Our Ref: EN010012

Date: 25 February 2021

Application by NNB Generation Company (SZC) Limited for an Order Granting Development Consent for The Sizewell C Project

Request for further information

NOTES:
 THIS PLAN ILLUSTRATES THE SIGNIFICANT TEMPORARY CONSTRUCTION INFRASTRUCTURE REQUIRED. FOR THE AVOIDANCE OF DOUBT IT DOES NOT INCLUDE CRANES, PLANT, OTHER MACHINERY OR PERMANENT INFRASTRUCTURE (UNLESS OTHERWISE SPECIFICALLY REQUESTED BY THE EXAMINING AUTHORITY).

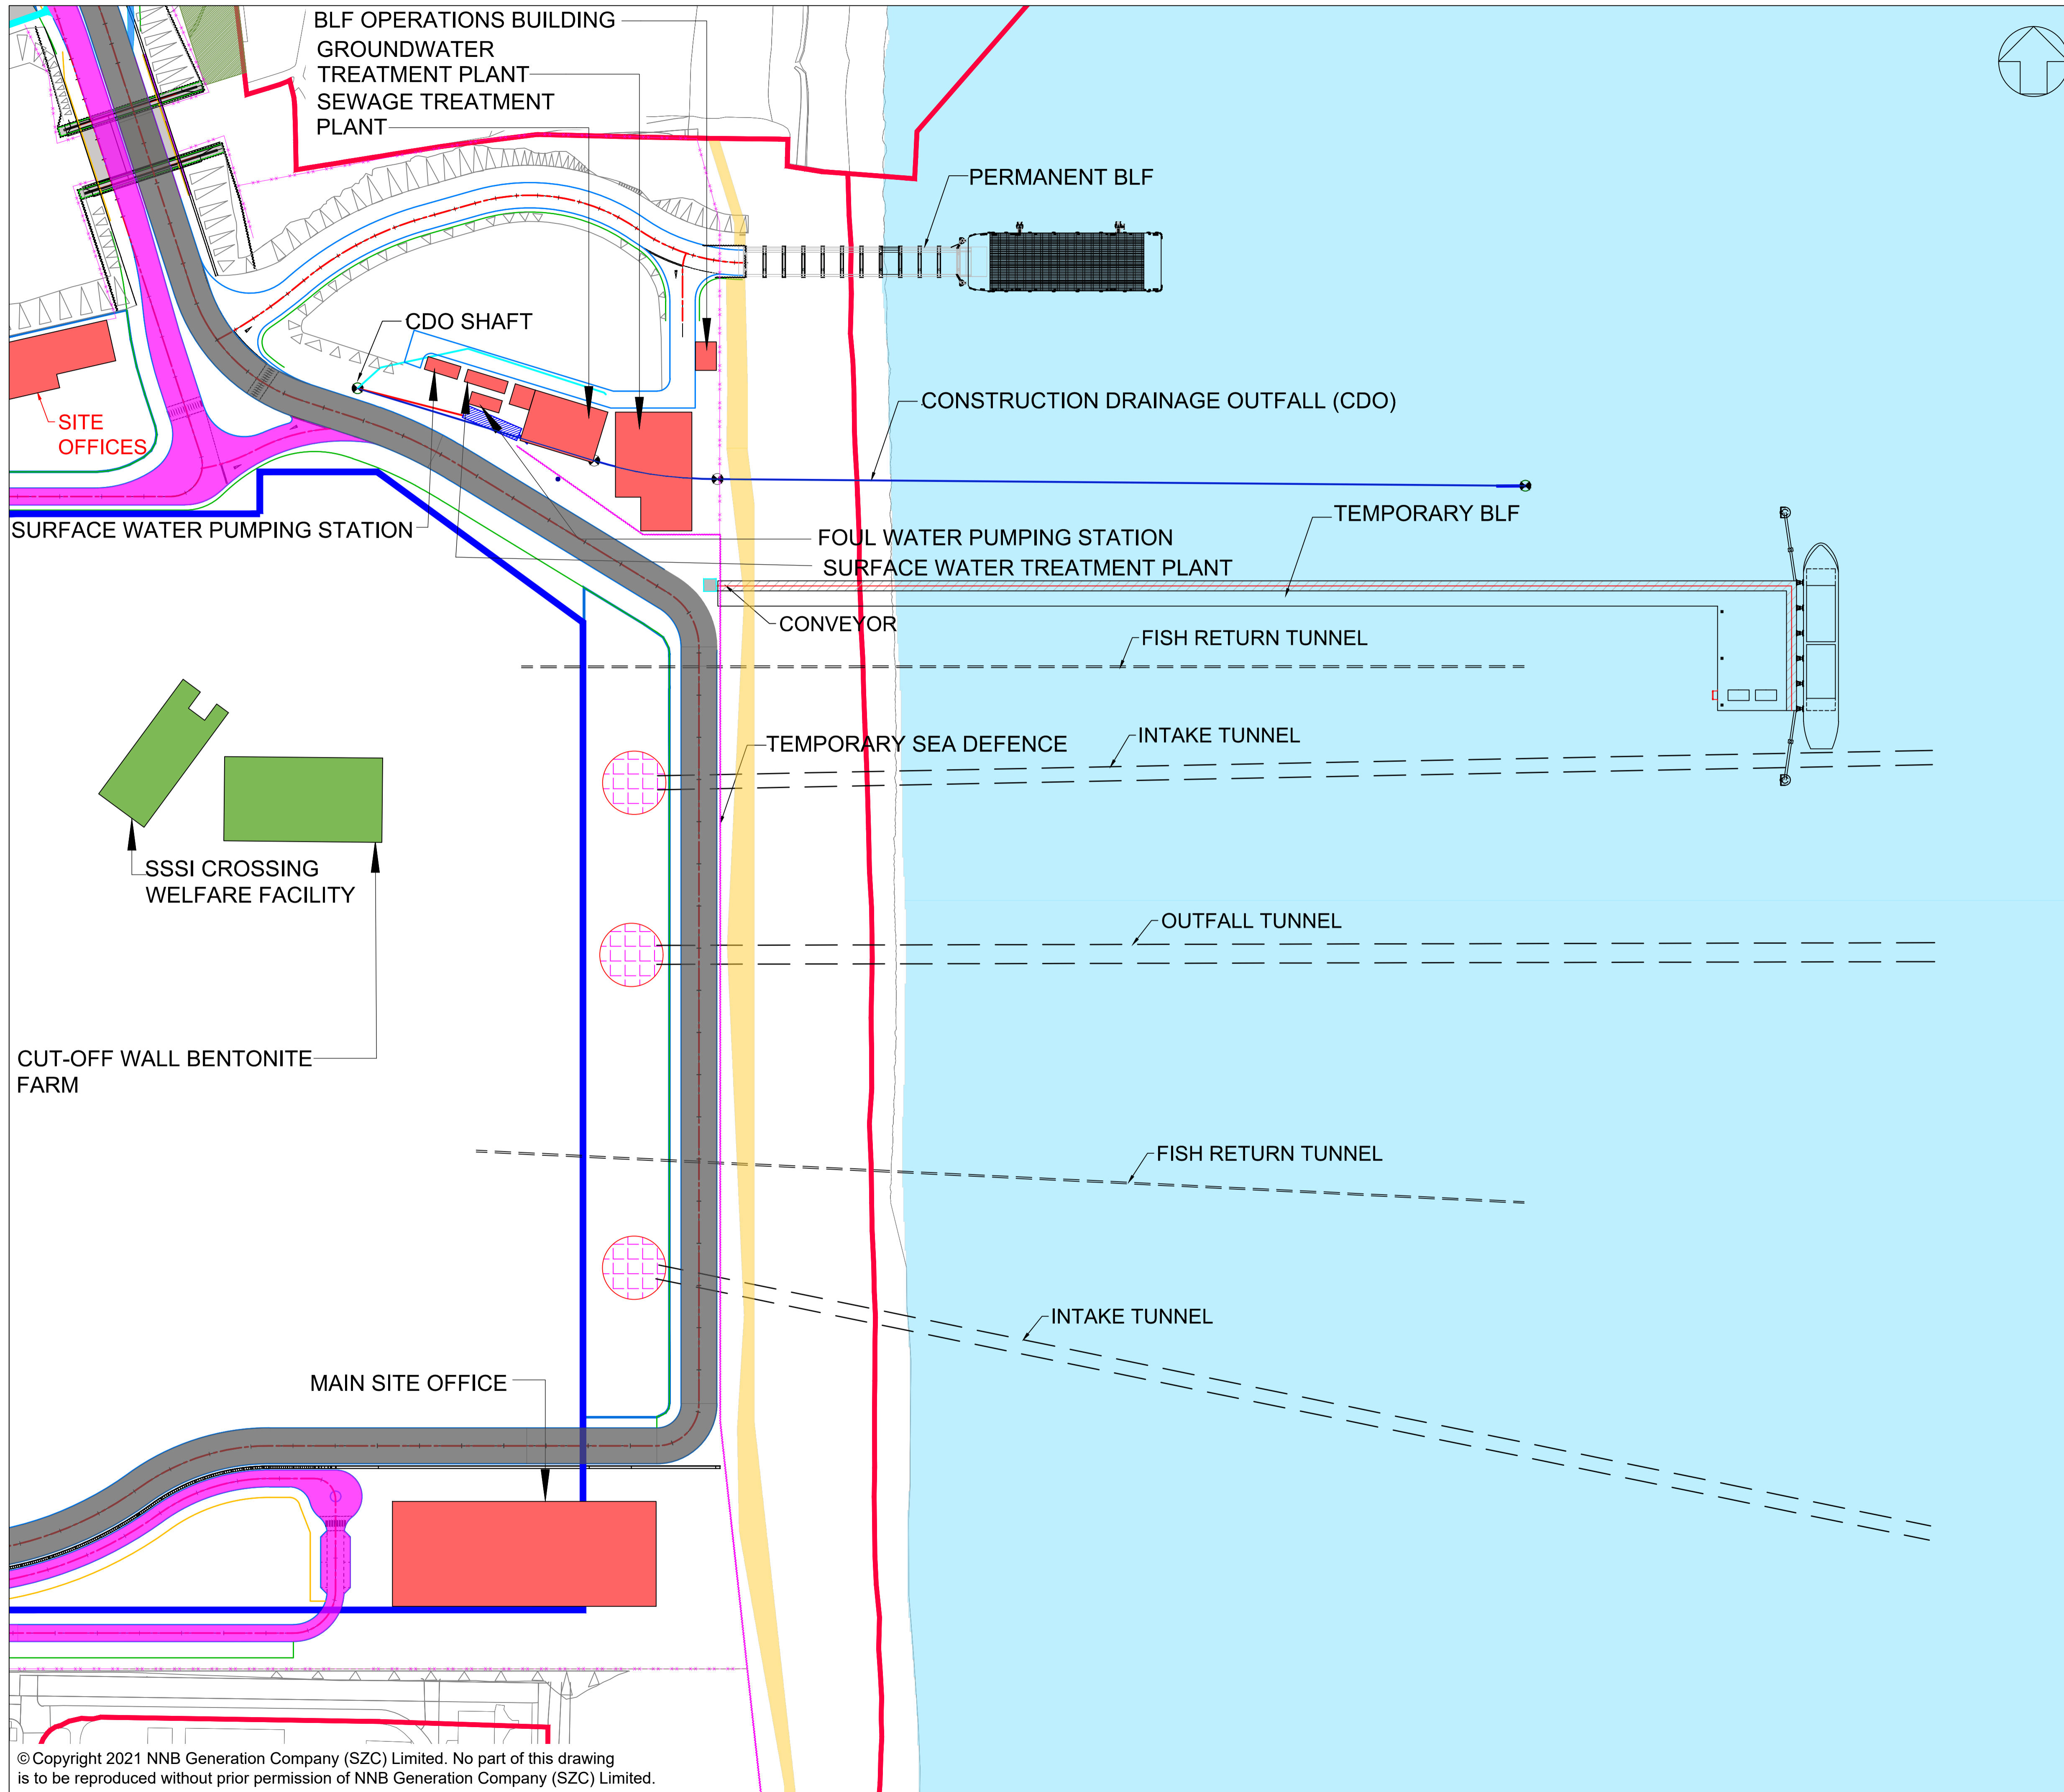
In addition, provide a detailed plan of the temporary construction area on the seaward side of the platform extending from the end of the SSSI crossing to the southern end of the main platform, including the ends of both BLFs.

Indicate on this plan:

- Any section of permanent access road, including that to the permanent BLF, within the area of the plan;
- Any temporary haul roads;
- Marine tunnelling shafts;
- The conveyor belt from the temporary BLF and any infrastructure; required to transfer materials from the conveyor belt; and
- Any other significant temporary construction infrastructure in this area.

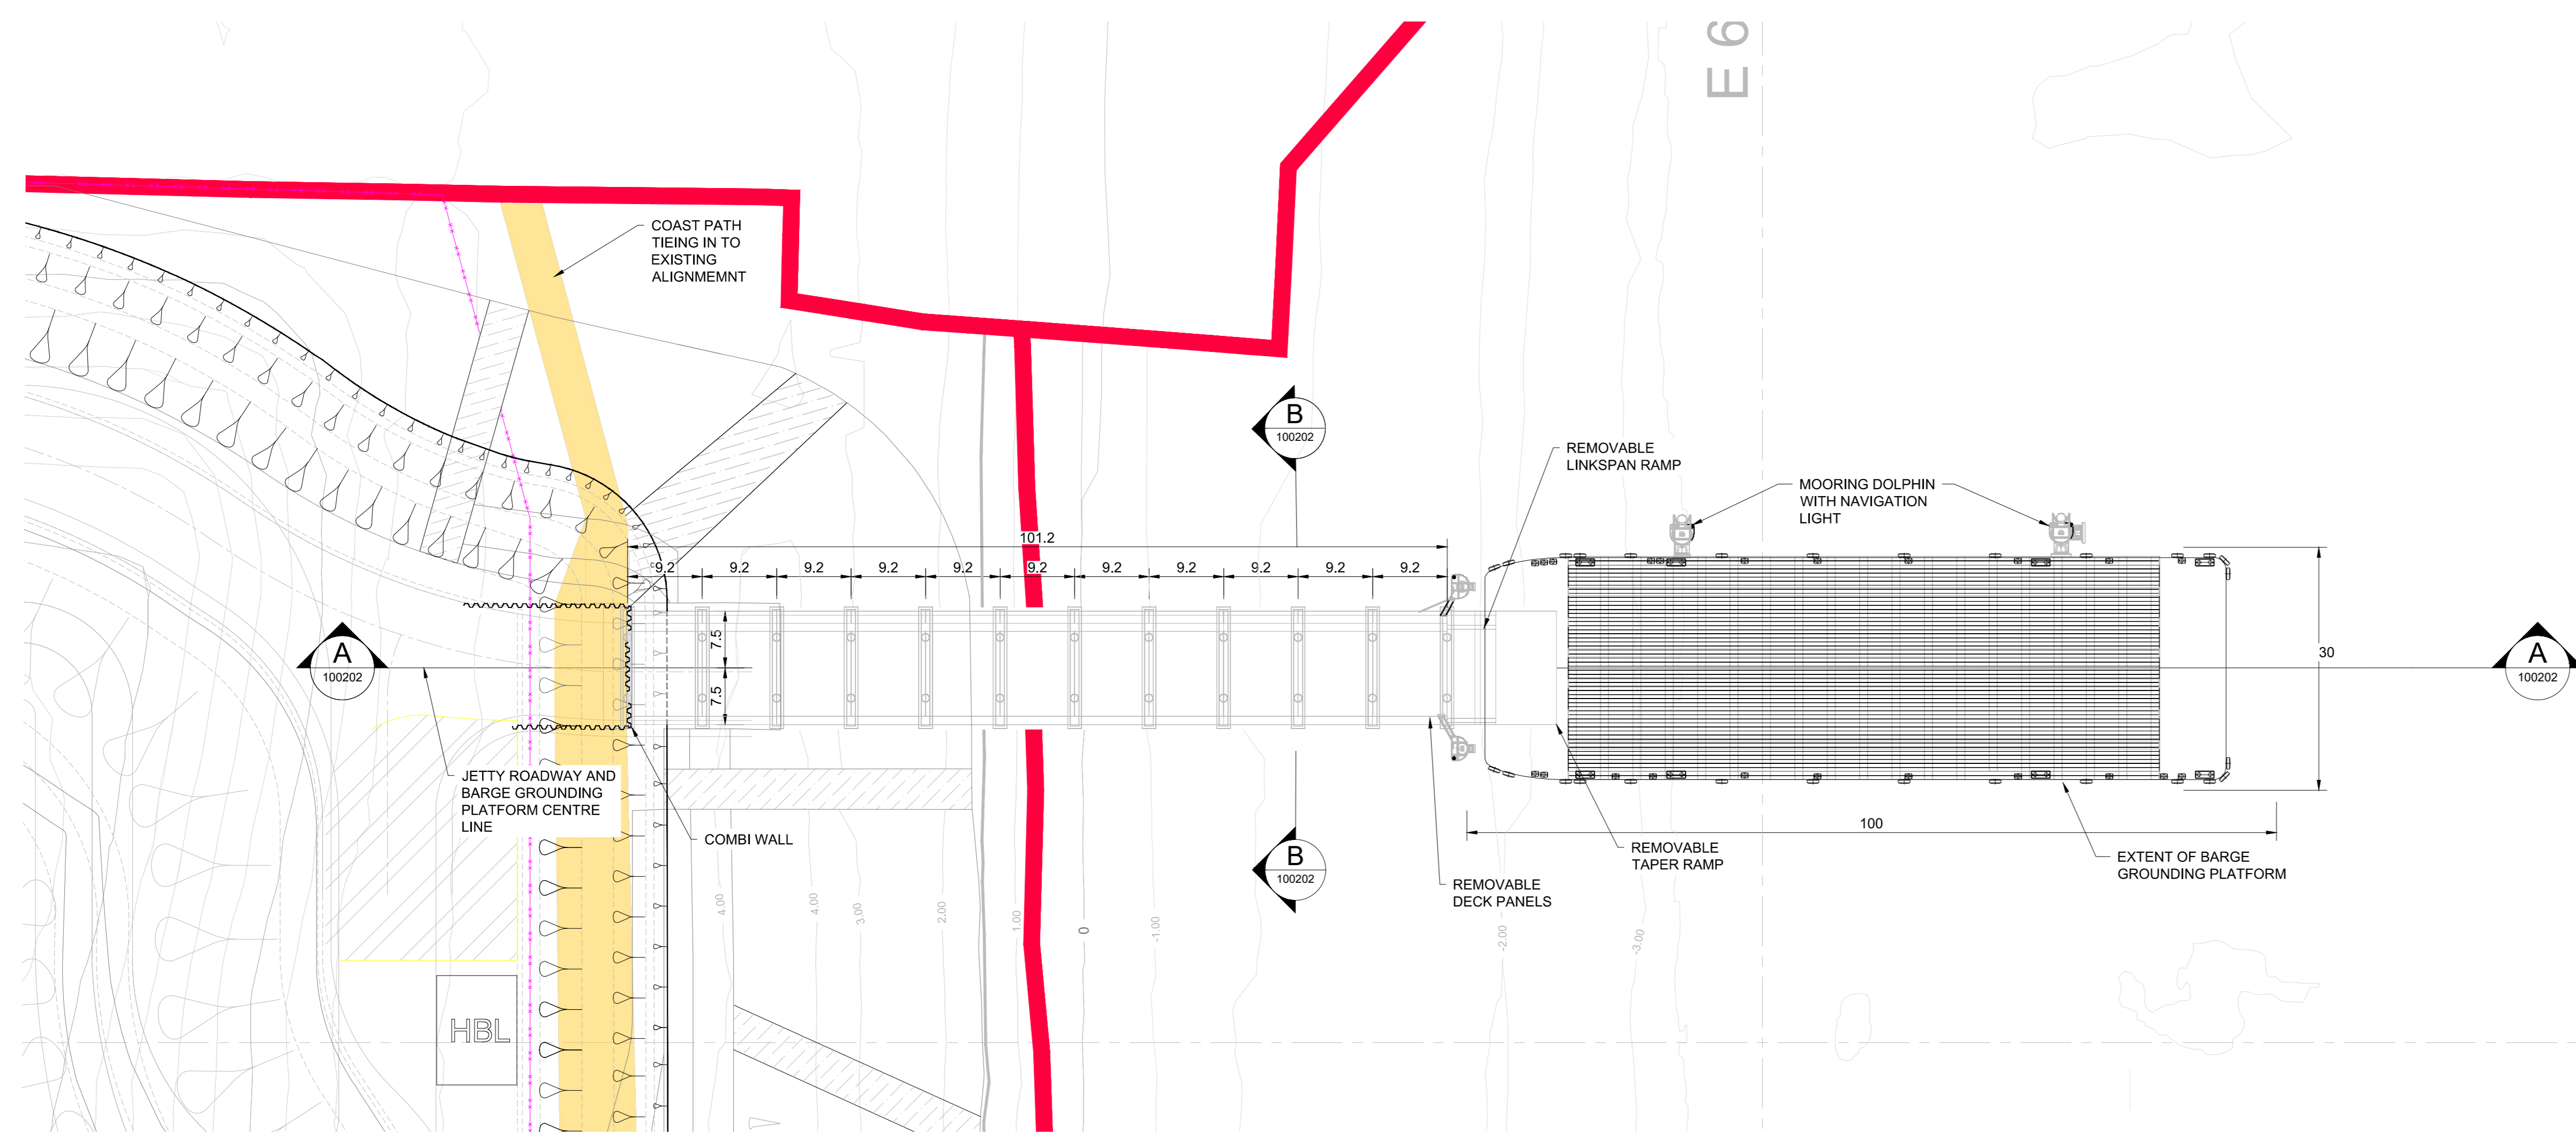
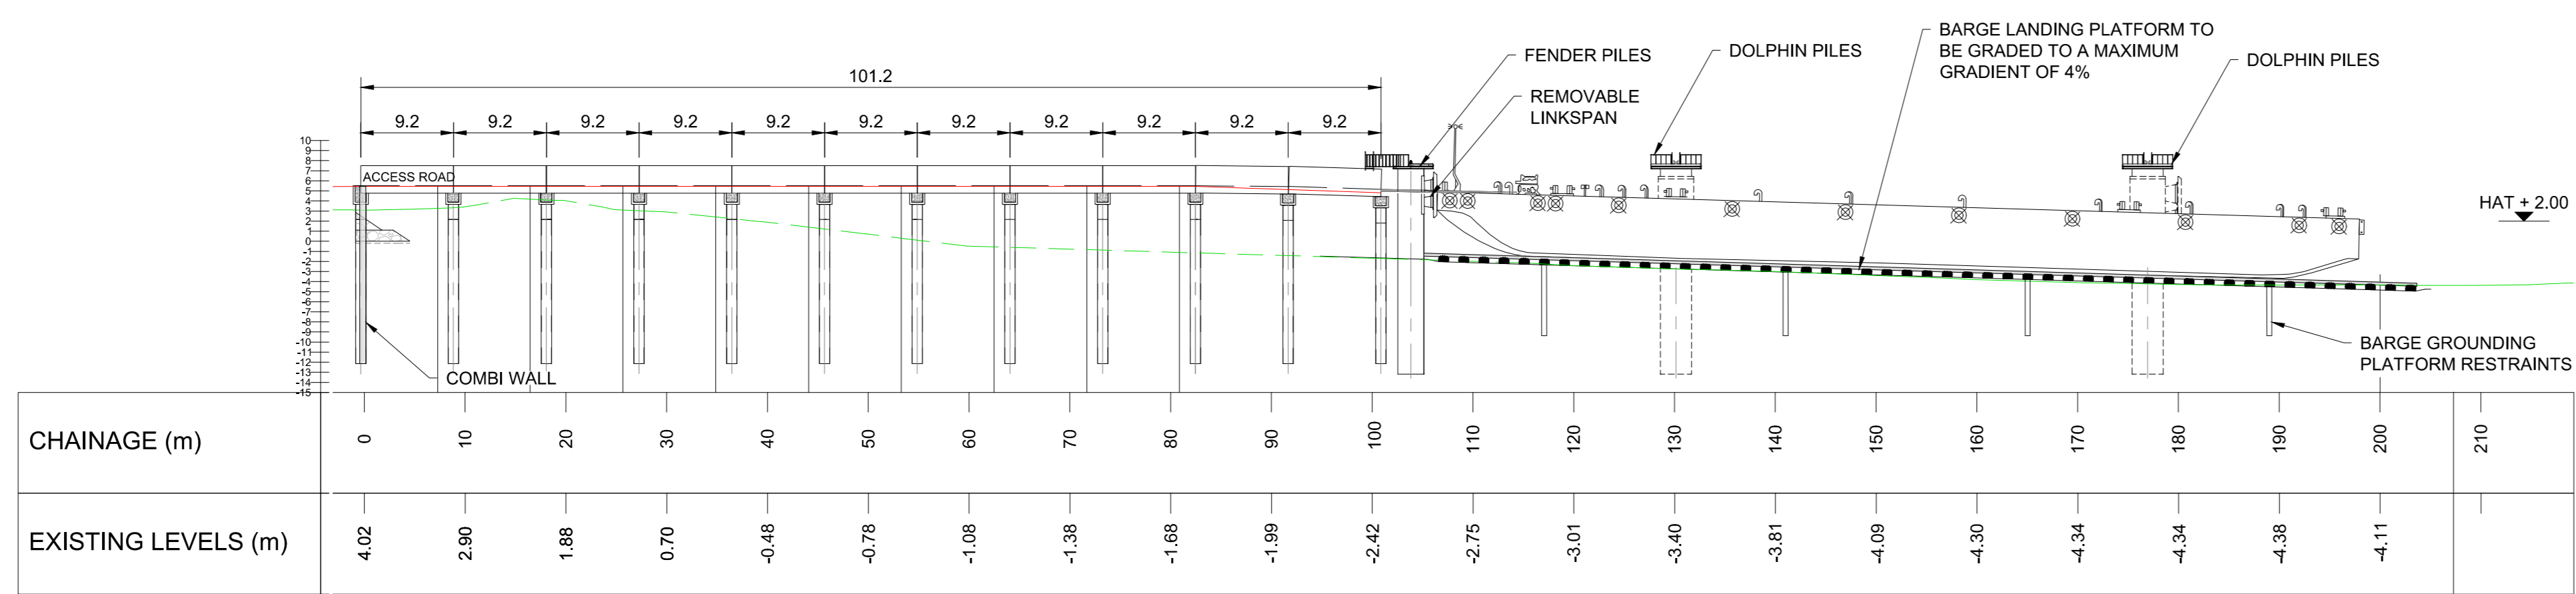
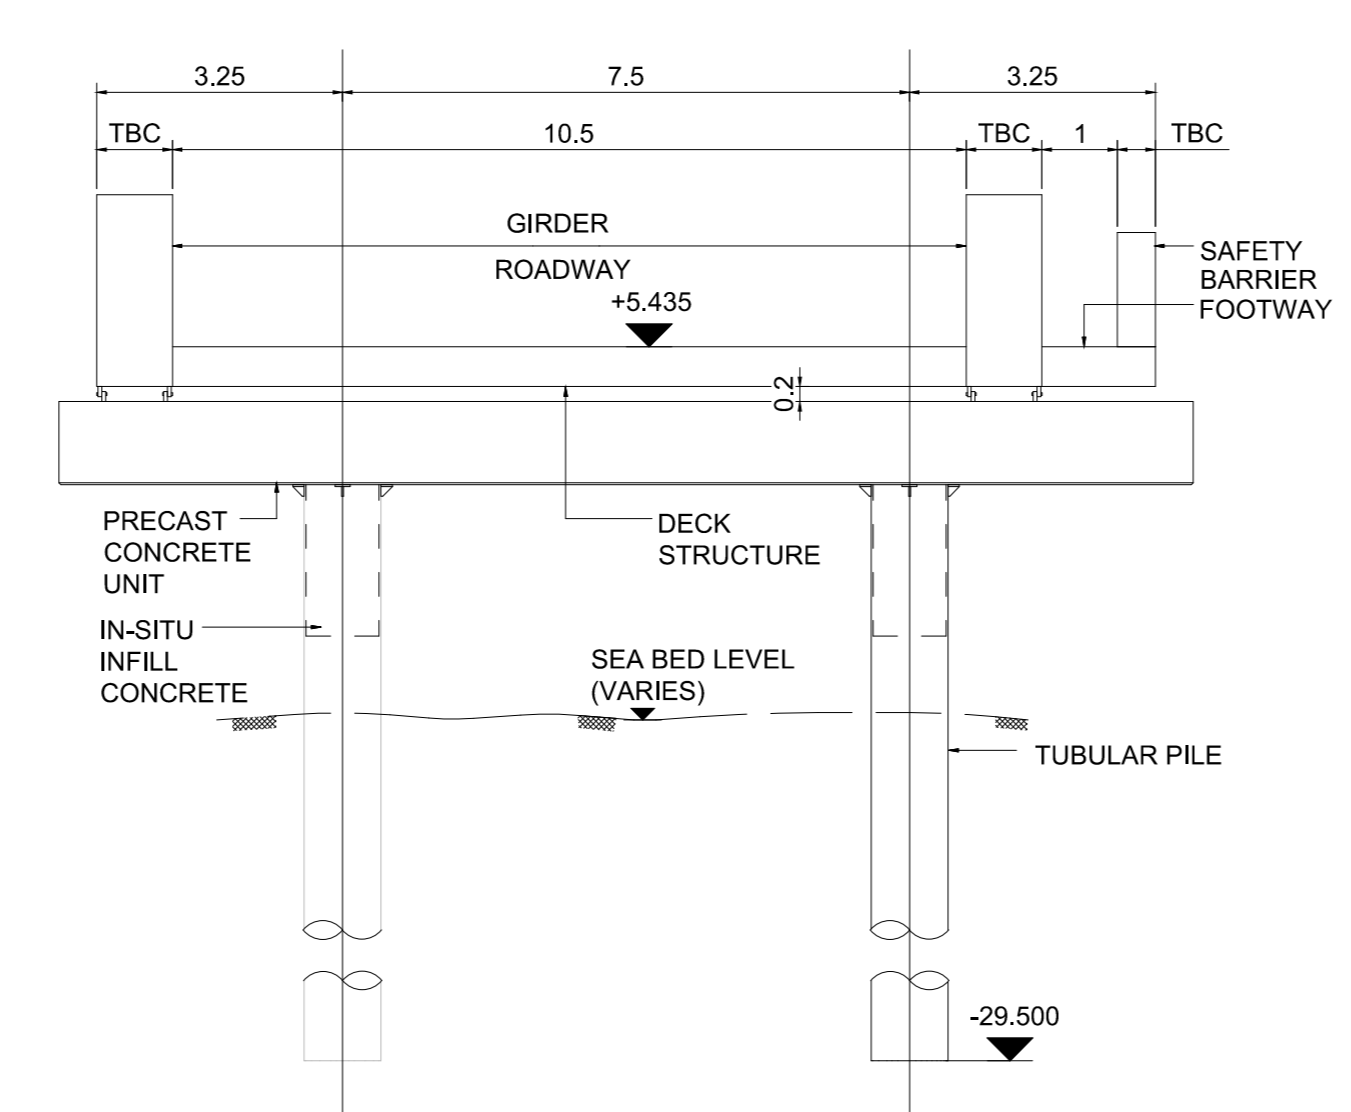
1. **Change number 2**, Enhancement of the permanent beach landing facility (BLF) and temporary BLF.

Please provide detailed plans, including cross and longitudinal sections, of both the enhanced permanent and temporary BLFs.

In respect of the temporary BLF, please also indicate the following where relevant:

- the conveyor belt and any associated infrastructure;
- Any lighting provided on the temporary BLF; and
- Any other structures / facilities on the temporary BLF.

In addition, please provide detailed plans, including cross and longitudinal sections, of the permanent BLF as submitted in the original application.
